**Consultation Response from KC,  
 Lead Local Flood Authority**

**2024/93326 Bradley Nursery, Bradley Junction Industrial Estate, Leeds Road, Bradley,  
 Huddersfield, HD2 1UR**

**Provision of a temporary compound as part of the Transpennine Route Upgrade Programme**

**Date Responded: 13/02/2025.**

Drawing Title
**BRADLEY JUNCTION
COMPOUND SITE
LEVELS AND
DRAINAGE**

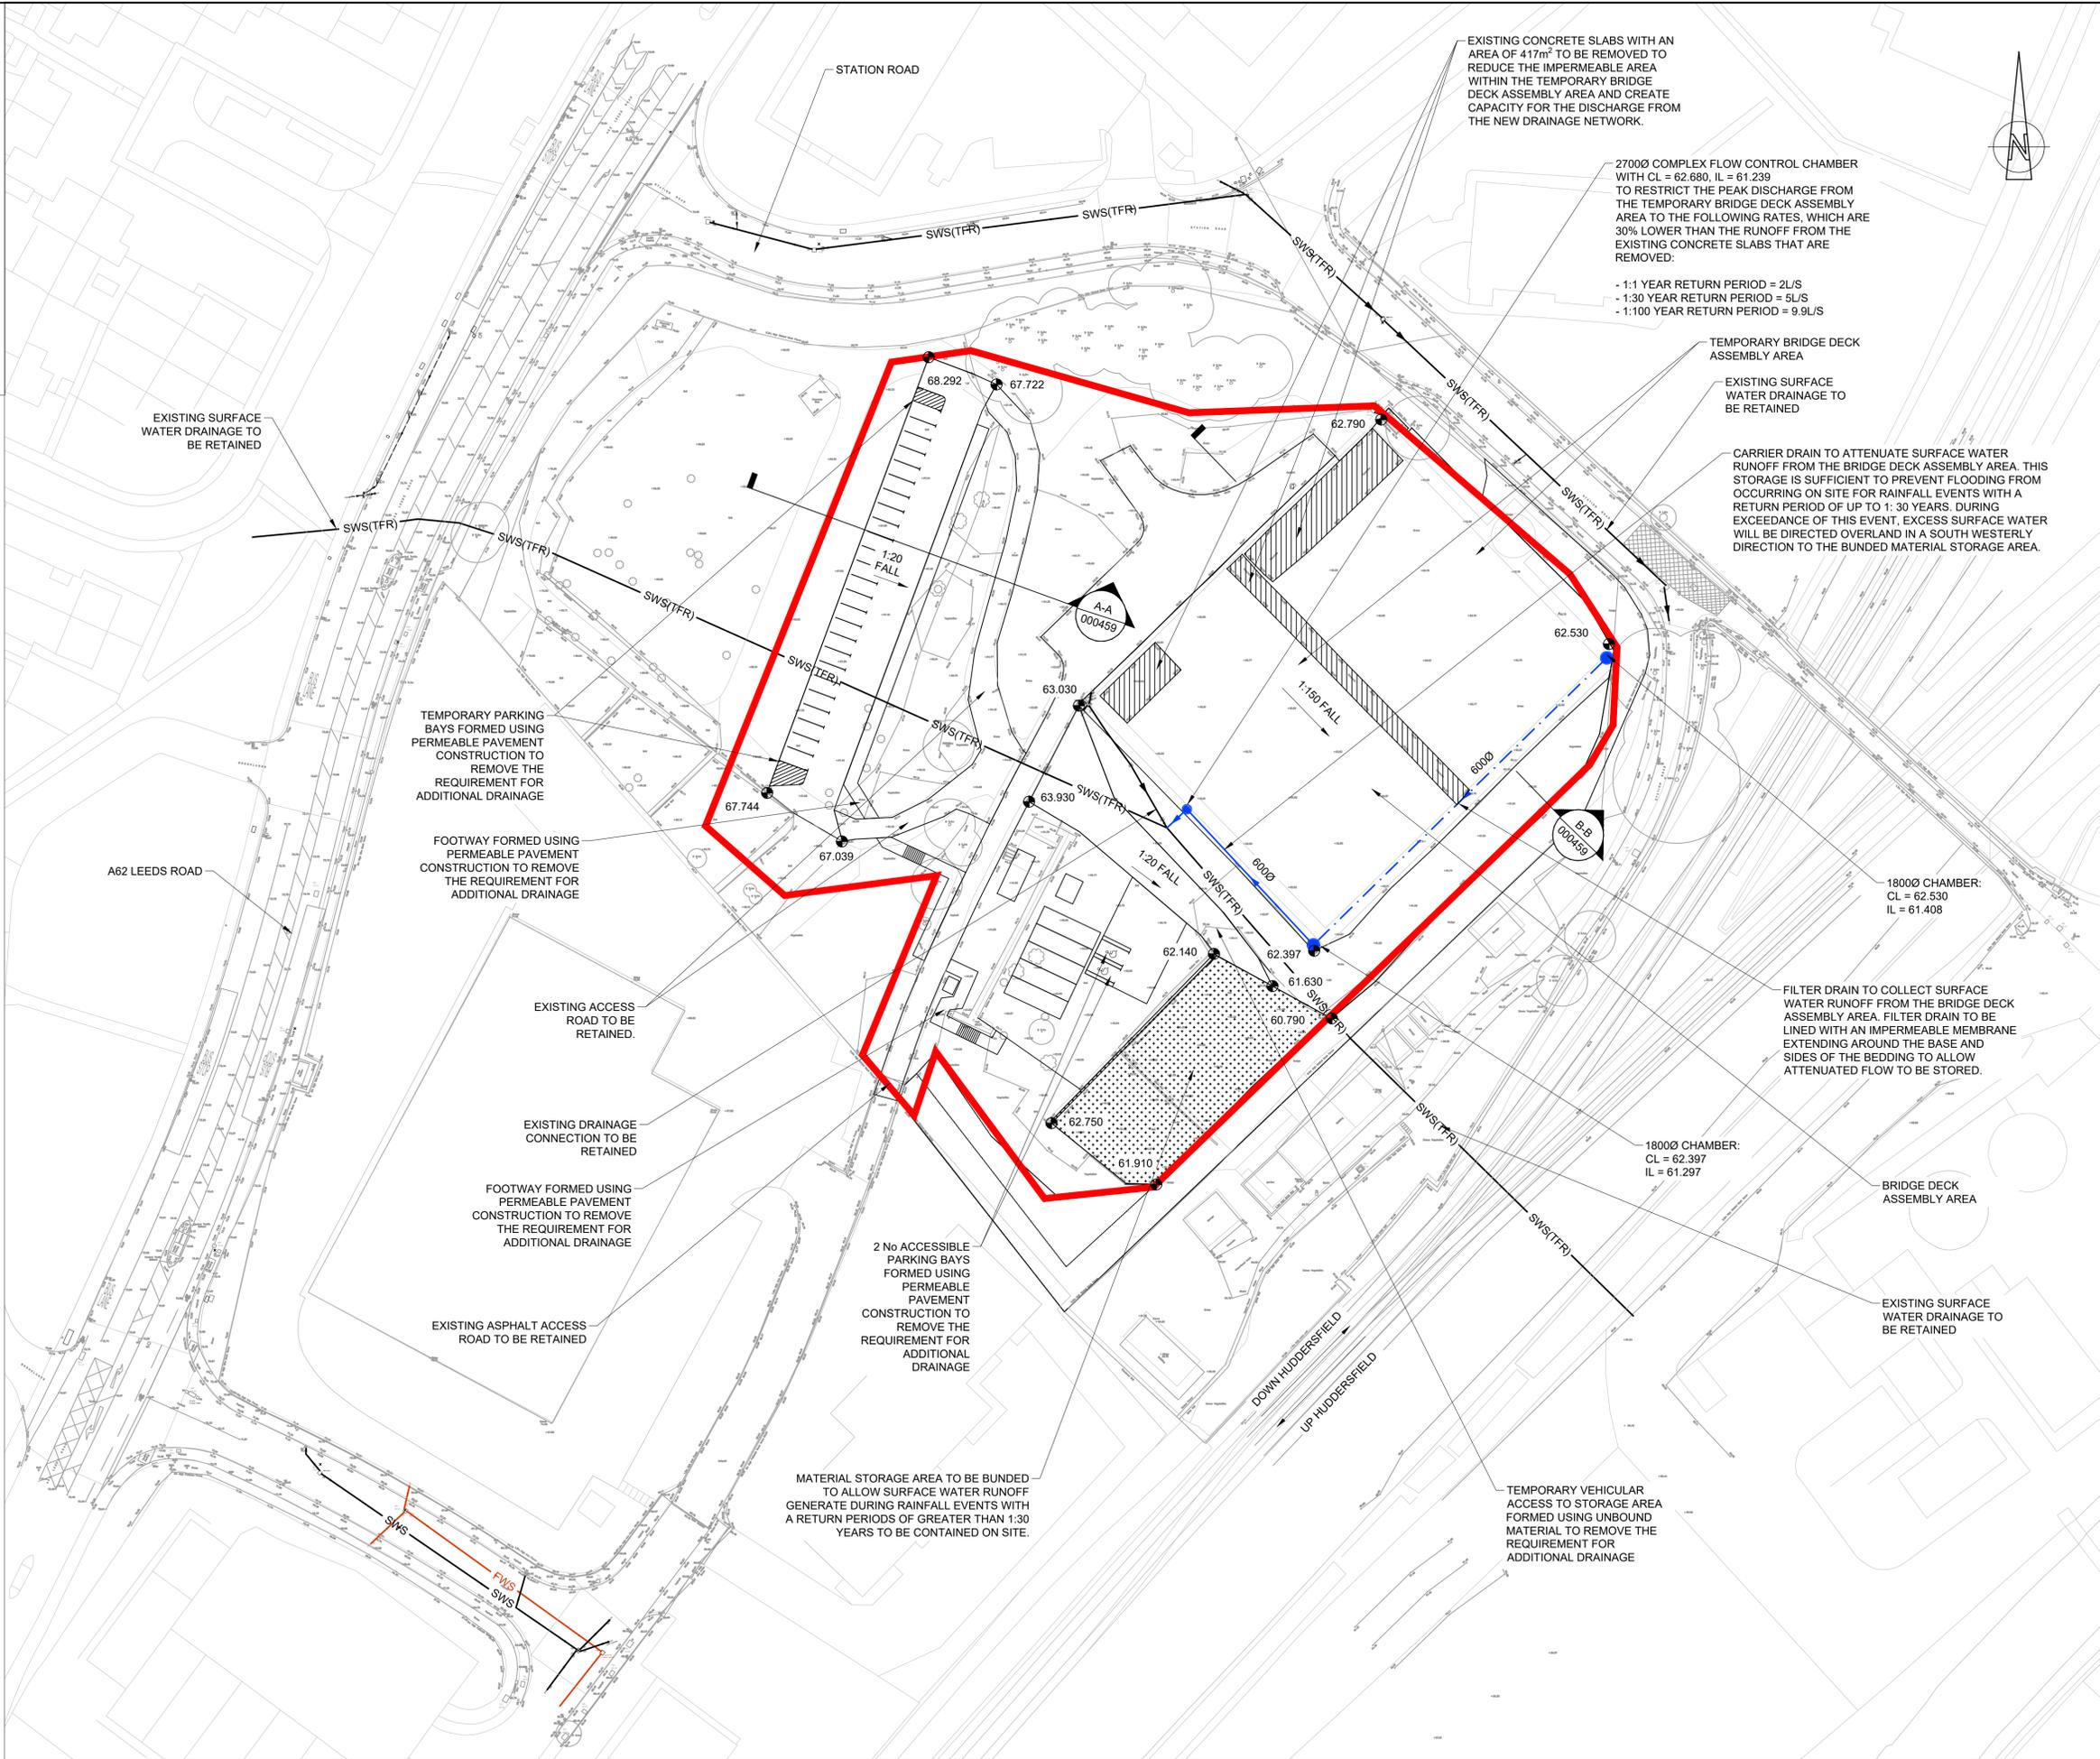
The drainage drawing indicates a Complex Flow Control – however, the LLFA requires a flow control device rated at **5.0l/s** only with attenuation storage sufficient to cater for the critical 1 in 100 year (plus climate change) rainfall event without flooding off-site.

Hydraulic calculations (e.g. MicroDrainage, Causeway) should be submitted to the LPA for LLFA comment confirming that the proposed attenuation volume is sufficient.

Development shall not commence until a detailed design scheme detailing foul, surface water and land drainage, including agreed discharge rate of **5.0l/s** indirectly or directly to watercourse, attenuation for the critical 1 in 100 (plus an allowance for climate change) rainfall event, attenuation construction details /design, plans and longitudinal sections, hydraulic calculations and phasing of drainage provision has been submitted to and approved in writing by the Local Planning Authority. The scheme shall include a risk assessment and method statement, in accordance with CDM Regulations 2015, for access to and into the attenuation structure, and the scheme shall include a maintenance and management plan for surface water infrastructure. No part of the development shall be occupied until such approved drainage scheme has been provided on the site to serve the development or each agreed phasing of the development and retained thereafter.
